CITY OF ALBUQUERQUE

July 6, 2021

**RE: San Roque / La Serena
441 & 457 Coors Blvd NW
Grading & Drainage Plan and Drainage Report
Engineer's Stamp Date: 06/10/21
Hydrology File: J10D049**

Based upon the information provided in your submittal received 06/10/2021, the Grading & Drainage Plan and Drainage Report **are not** approved for Building Permit and action by the DRB on Preliminary Plat or Site Plan for Building Permit. The following comments need to be addressed for approval of the above referenced project:

Overall Grading & Drainage Plan

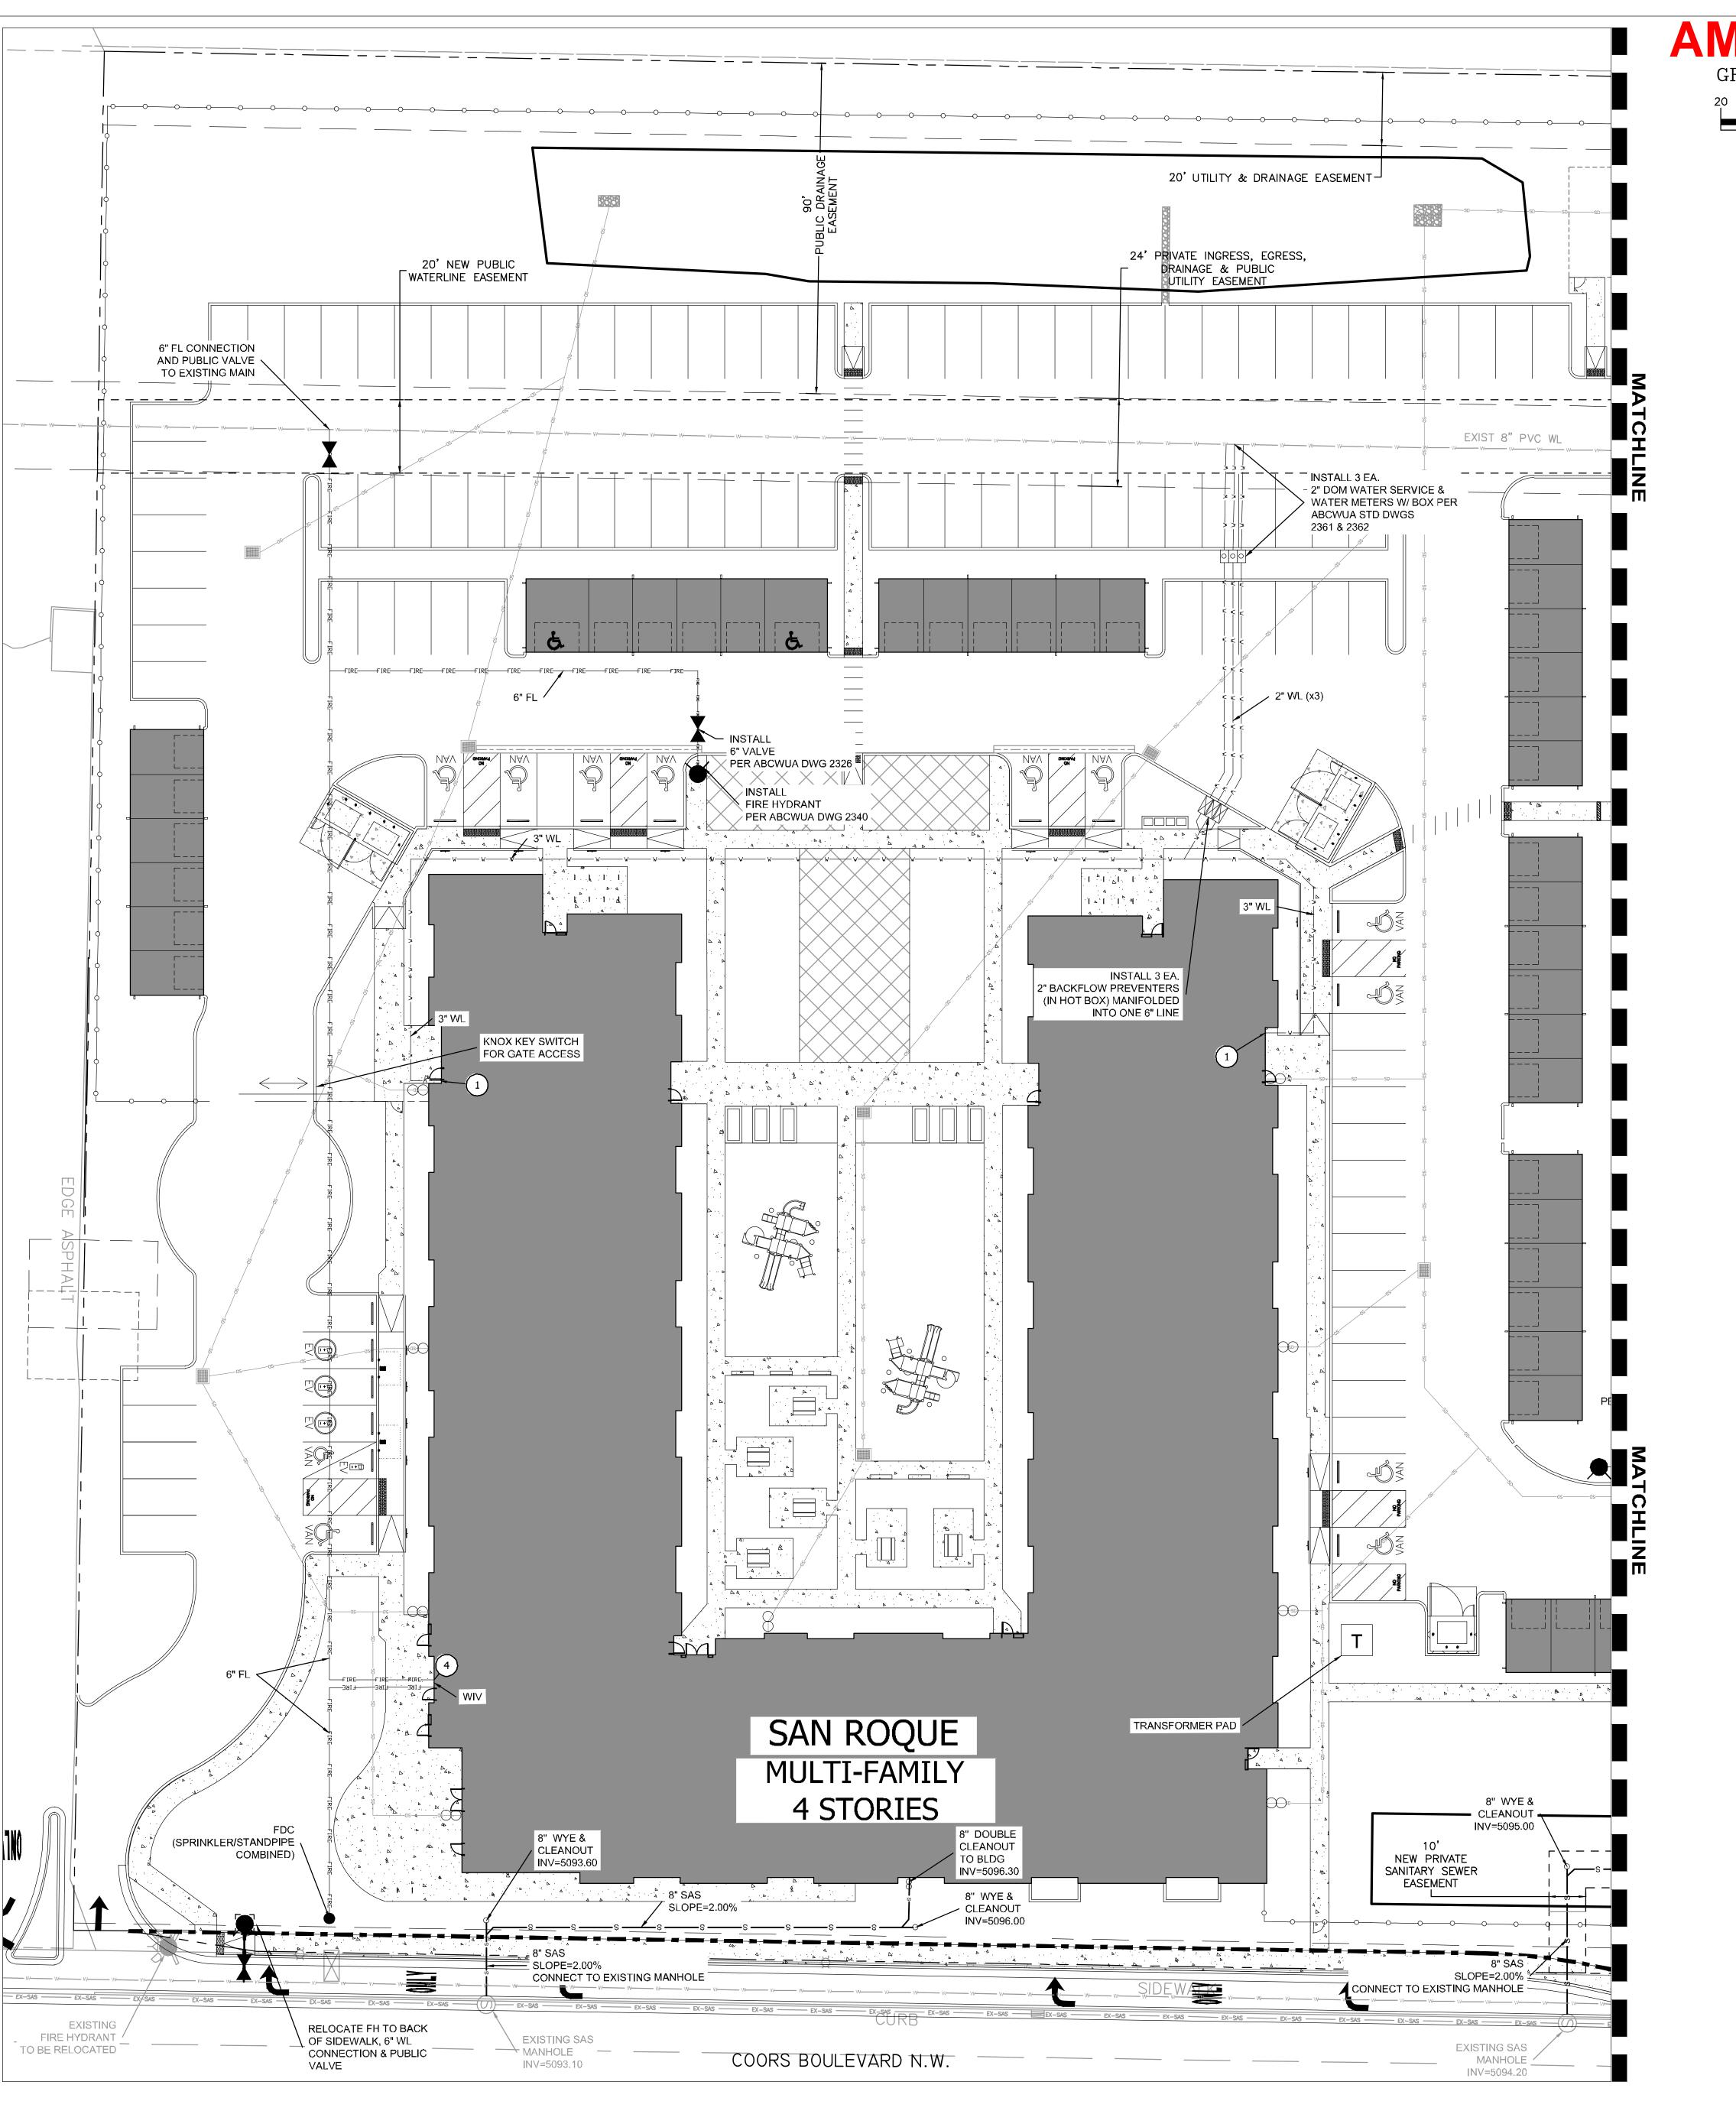
3. Since the site can freely discharge into the existing 60-in storm pipe, please remove and update all reference to the detention ponds since they are no longer needed. Also you may want to ask the architect if they wish to do something with this area since the detention ponds are not needed. Please remember to discharge into a revised stormwater quality ponds prior to the connection to this existing pipe.

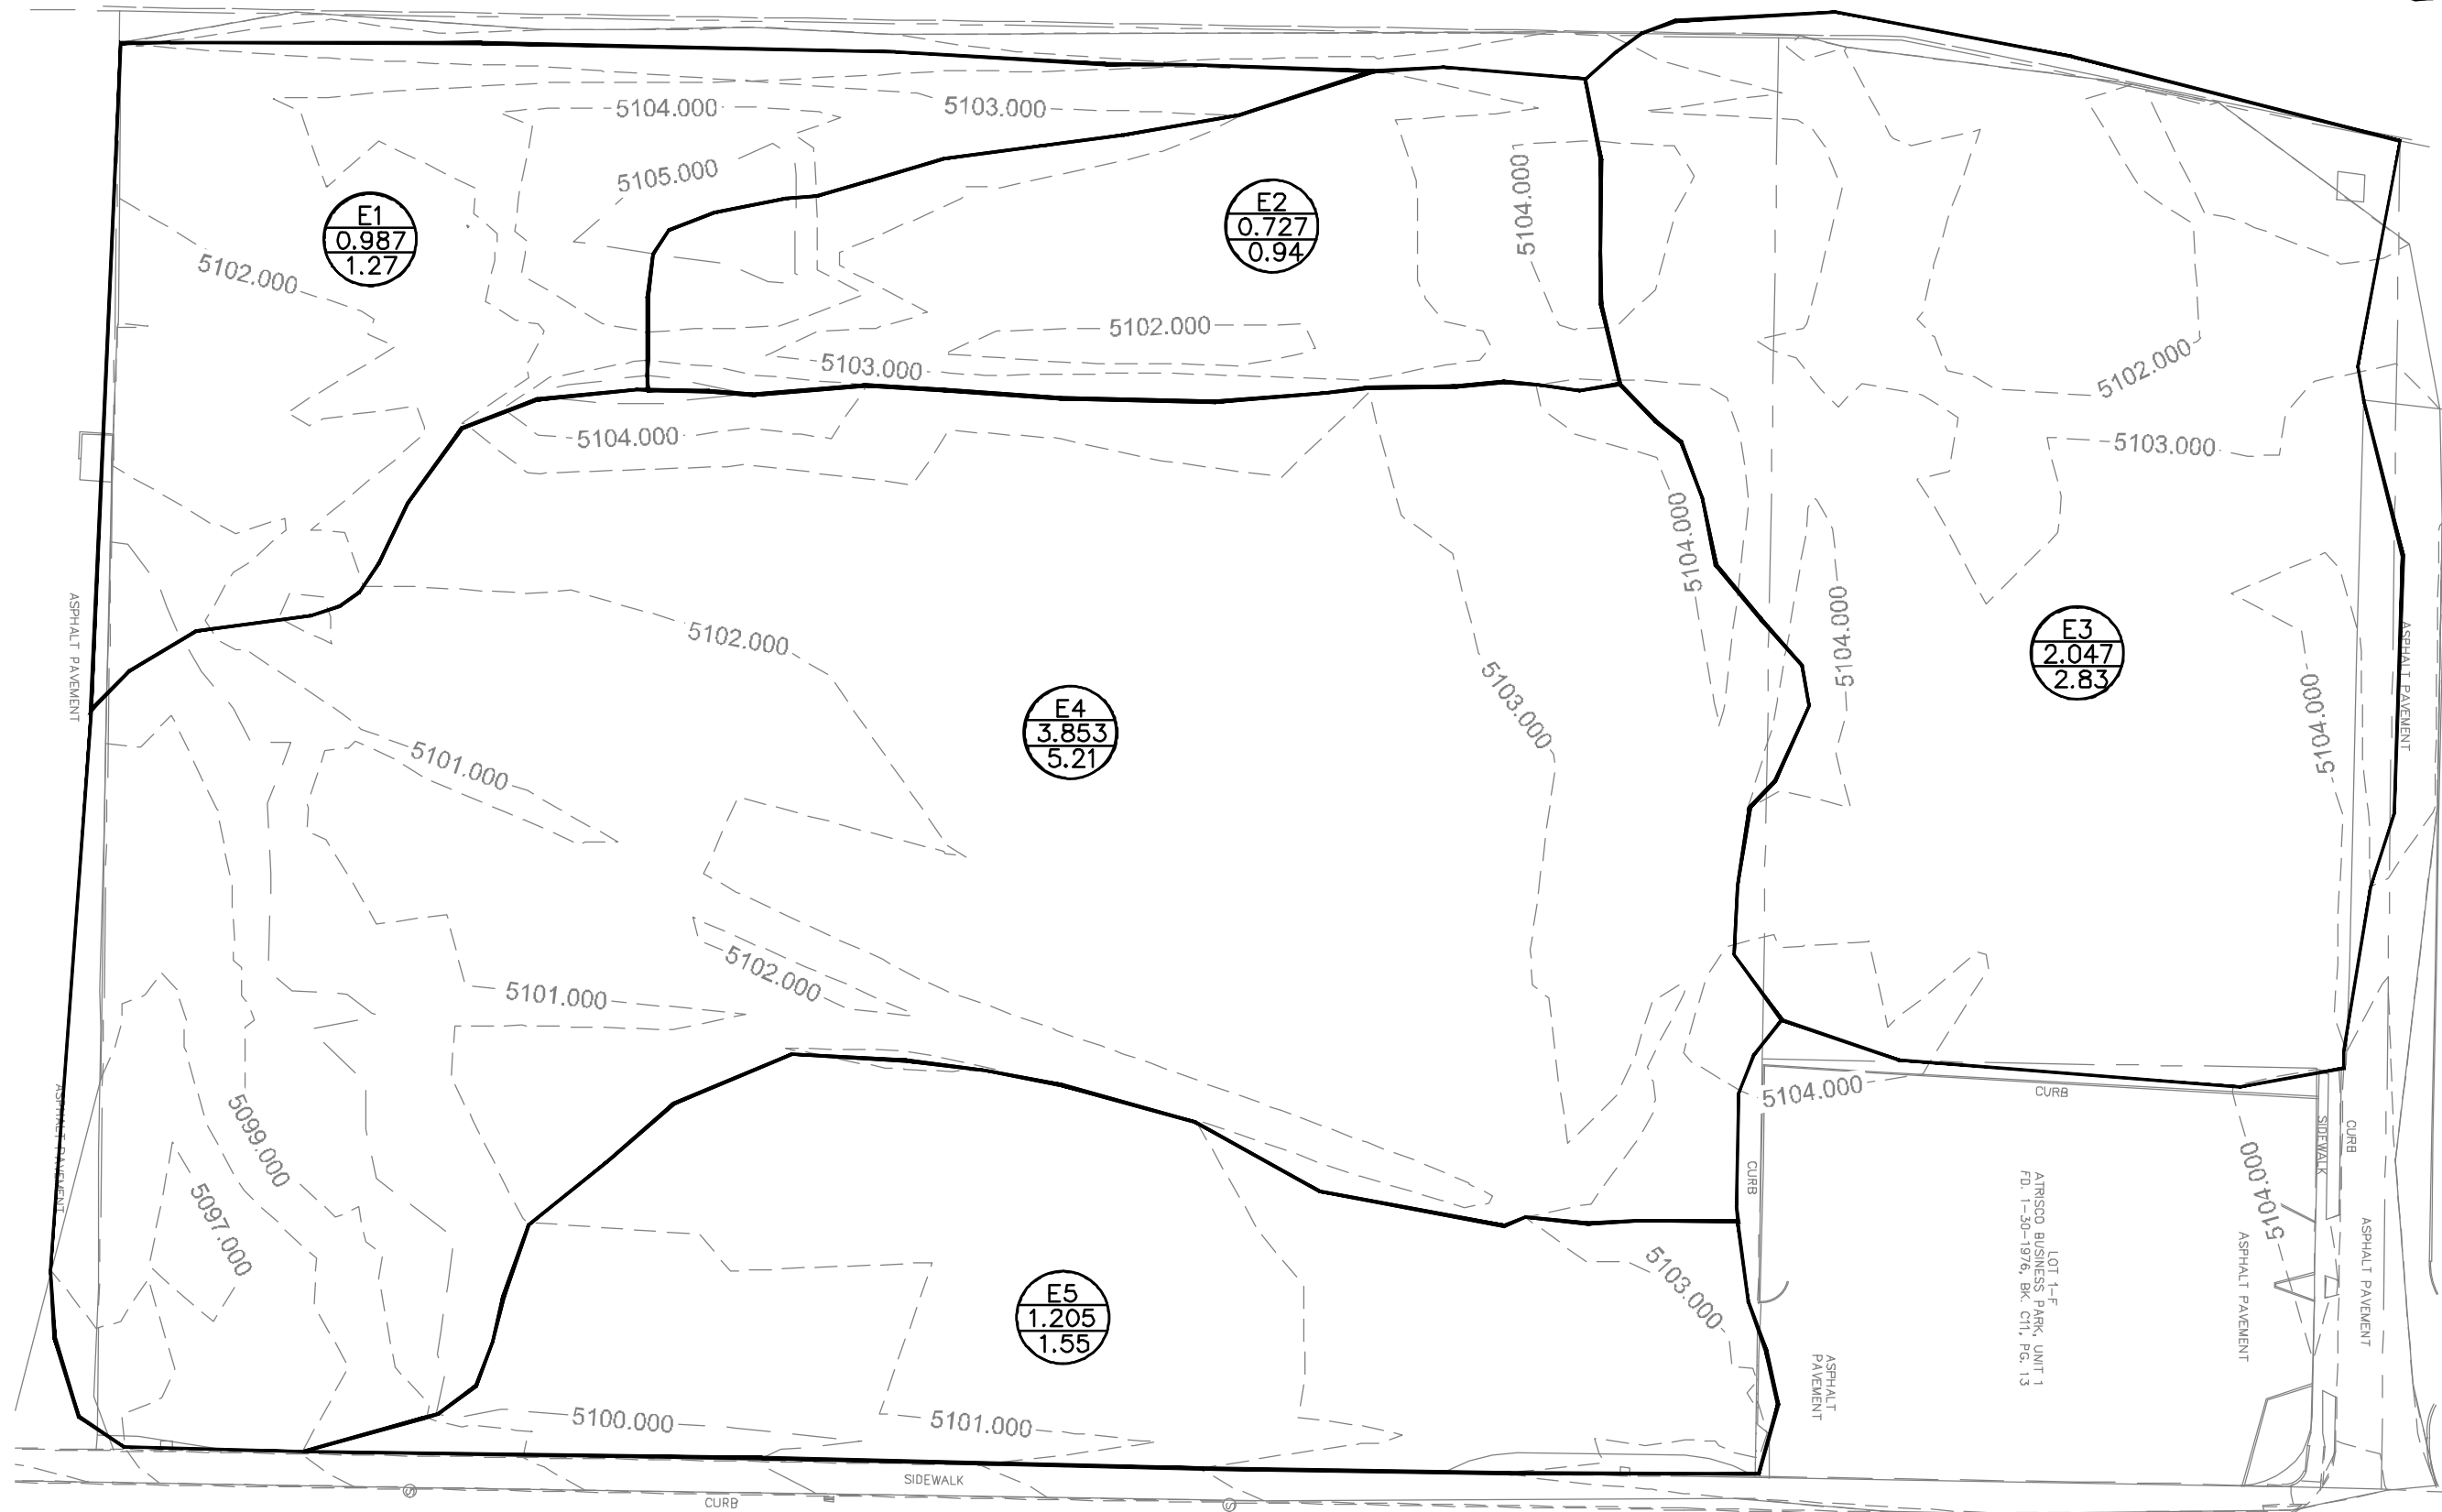
1. Under Existing Conditions, the report states, " This site lies within the Atrisco Business Park Master Plan.....". This is false, below is the basin map from the report and this site is not in the report area. However as noted, the existing 60-in public storm pipe stops on the project's site without any City's plans to extend the storm system. Therefore this site will be able to freely discharge into this existing 60-in with no problem since there is plenty of capacity. Please discharge into a revised stormwater quality pond prior to the connection to this existing pipe. (see below for the as-builts of that existing 60-in pipe)
